**WEST SUSSEX COUNTY COUNCIL
STRATEGIC PLANNING CONSULTATION**

SUBJECT: FG/198/16/PL - Demolition of existing house with erection of 2 storey building comprising of 8No. residential 2 bedroom flats & associated external works.

1, Sea Drive, Ferring, BN12 5HD

JOB: 1 SEA DRIVE, FERRING, WORTHING BN12 5HD
DWG: PROPOSED SITE PLAN

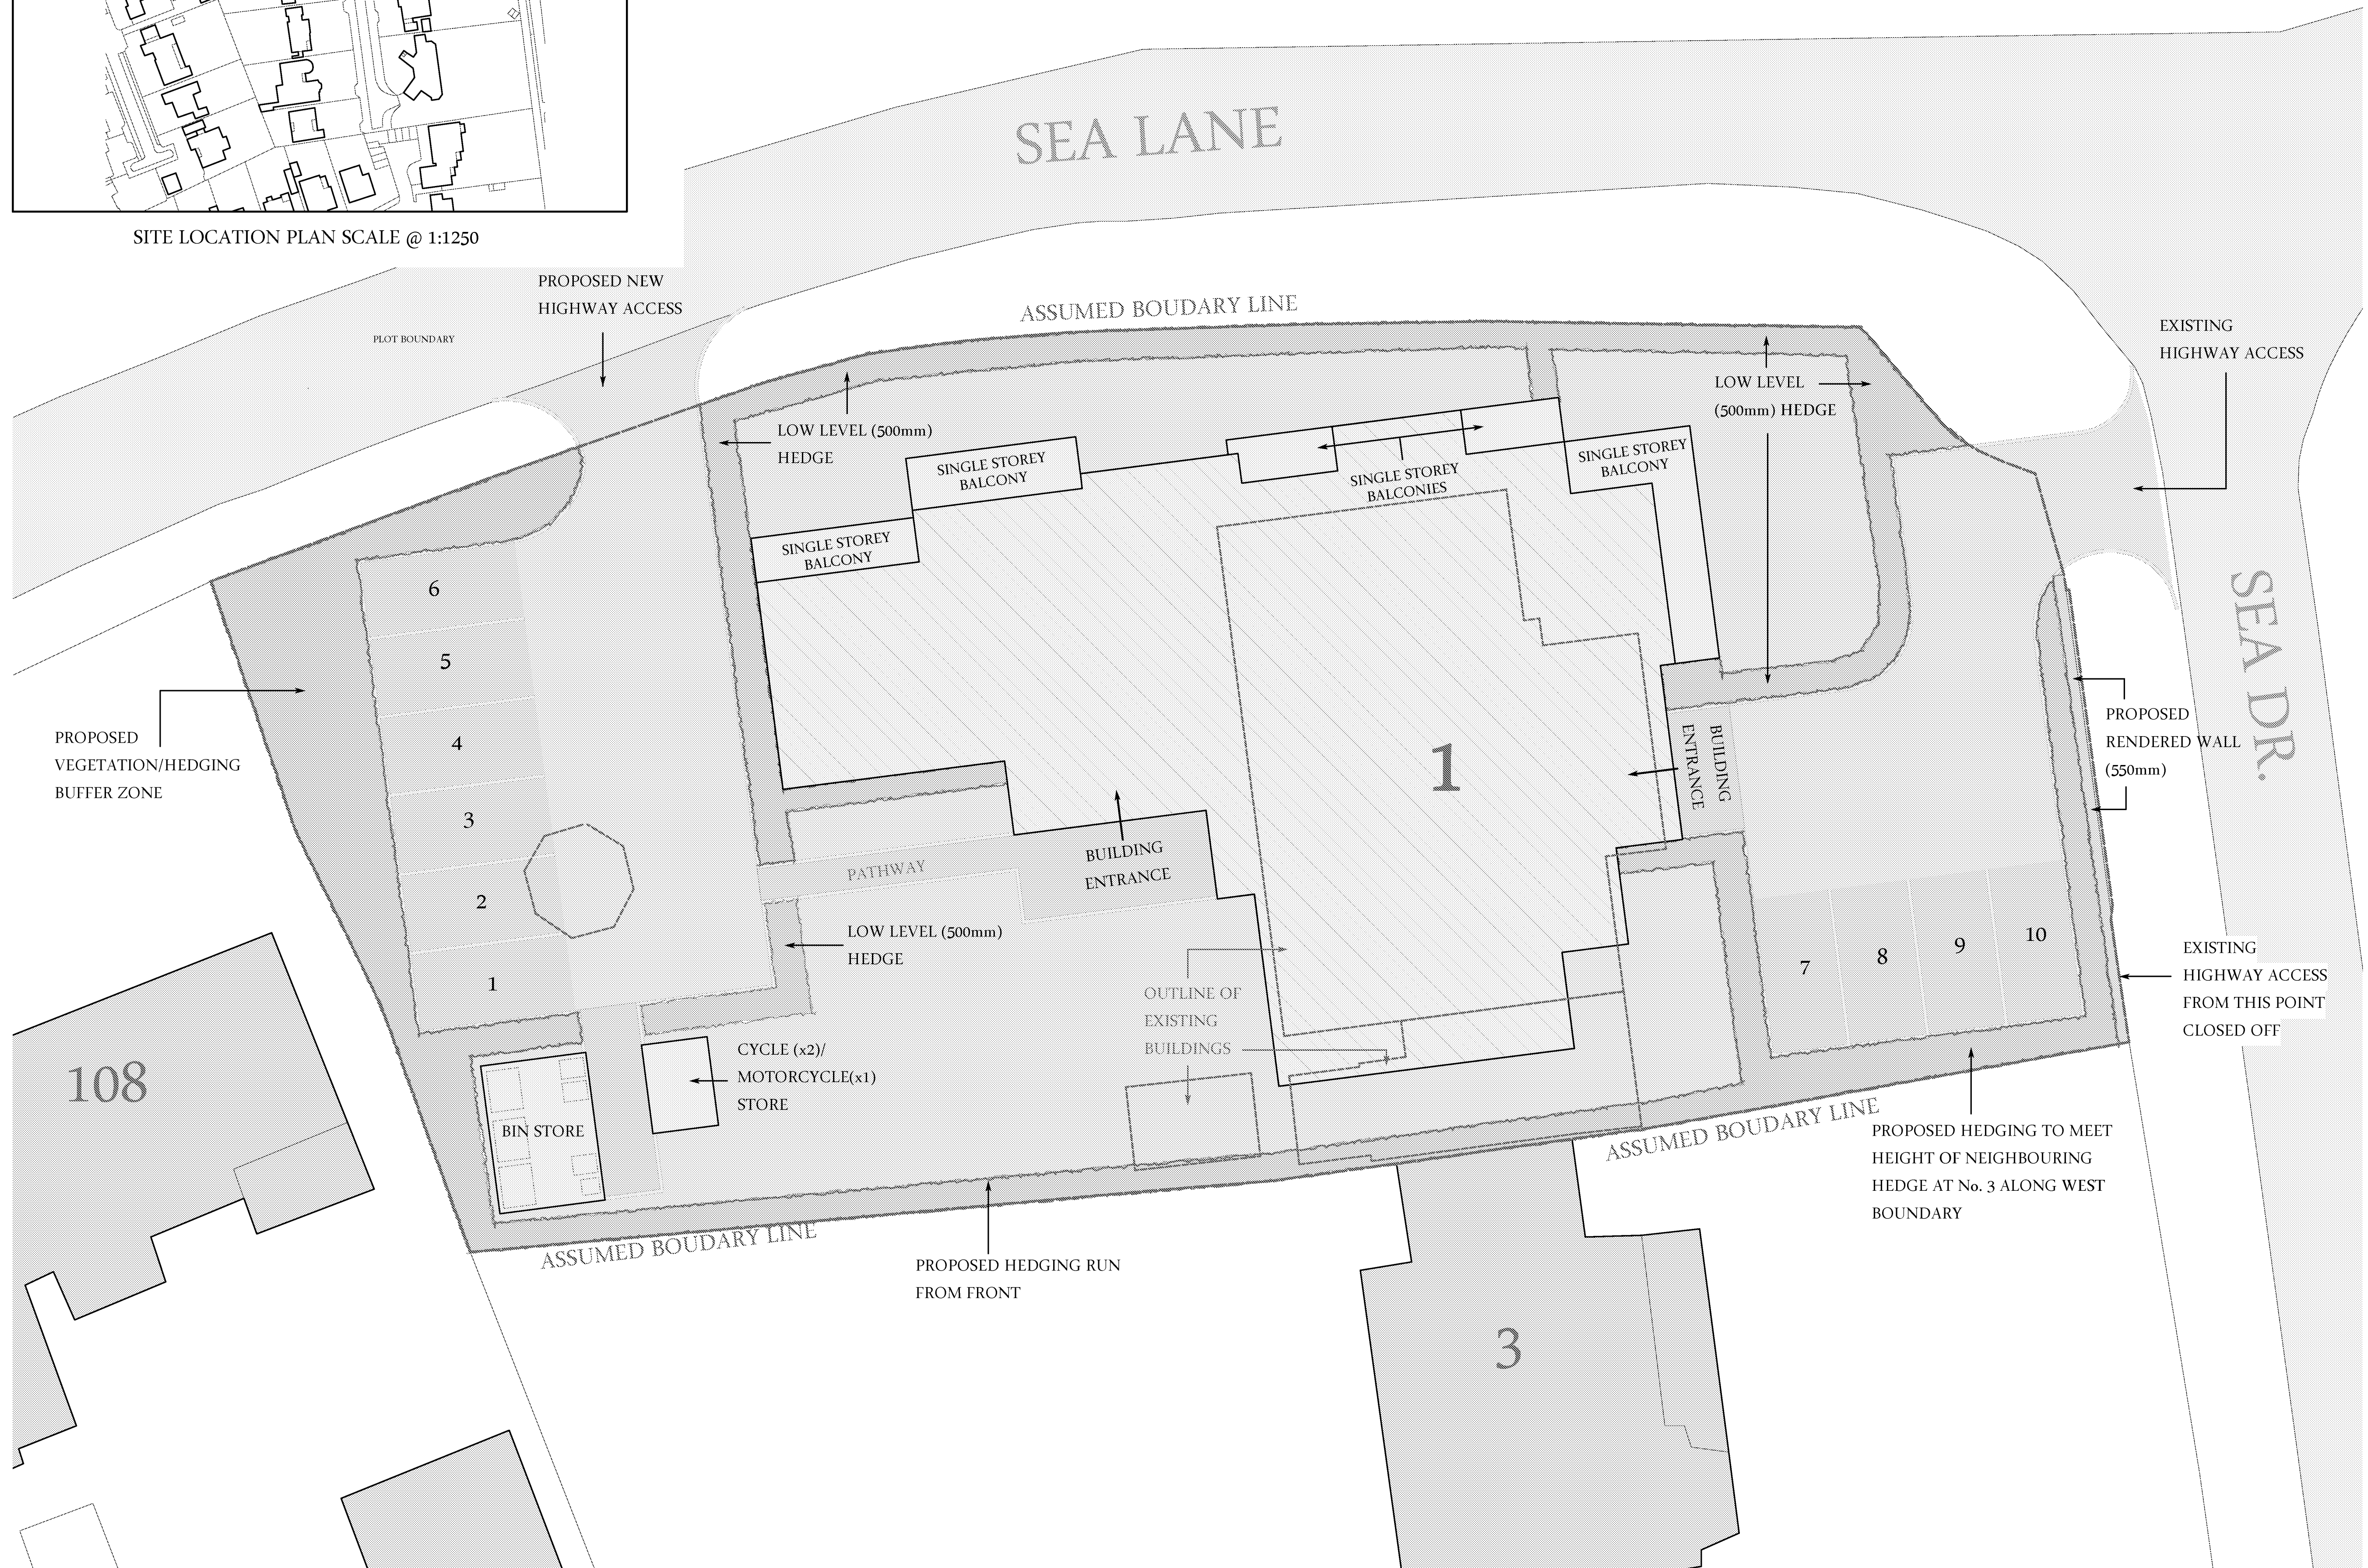
The site mentioned above currently has two access points onto Sea Drive, which is a private roadway. The LHA can only offer observations on private roadways as the LHA have no jurisdiction over them. The application documents indicate that one access will be closed off and one retained to gain access to parking spaces 7-10. It is not clear if the retained access will be widened to allow two opposing vehicles to pass, clarification is sought on this point.

A new access point is also proposed off of Sea Lane which is adopted highway. There are no details supplied with this application relating to access or traffic generation. The access would need to be 4.8m – 5m to allow two opposing vehicles to pass. It also needs to be fully demonstrated that visibility from the proposed access can be achieved. In this location Manual for Streets (MfS) would be the appropriate standards to apply. Sea Lane has a 30mph speed limit so splays from a setback of 2.4m x 43m in each direction need to be demonstrated and achievable.

At present based on the submitted detail the LHA would not be in a position to support this application; the following further information is sought;

- Detailed scaled access plan for both access points
- Scaled visibility plan demonstrating 2.4m x 43m splays onto Sea Lane
- Tracking to demonstrate that vehicles can manoeuvre on site to exit onto the highway in forward gear (in both parking areas)
- Details relating to refuse collection (i.e. will a refuse vehicle enter the site and if so tracking will need to be provided to demonstrate such a vehicle can enter, turn on site and exit onto the highway in forward gear)
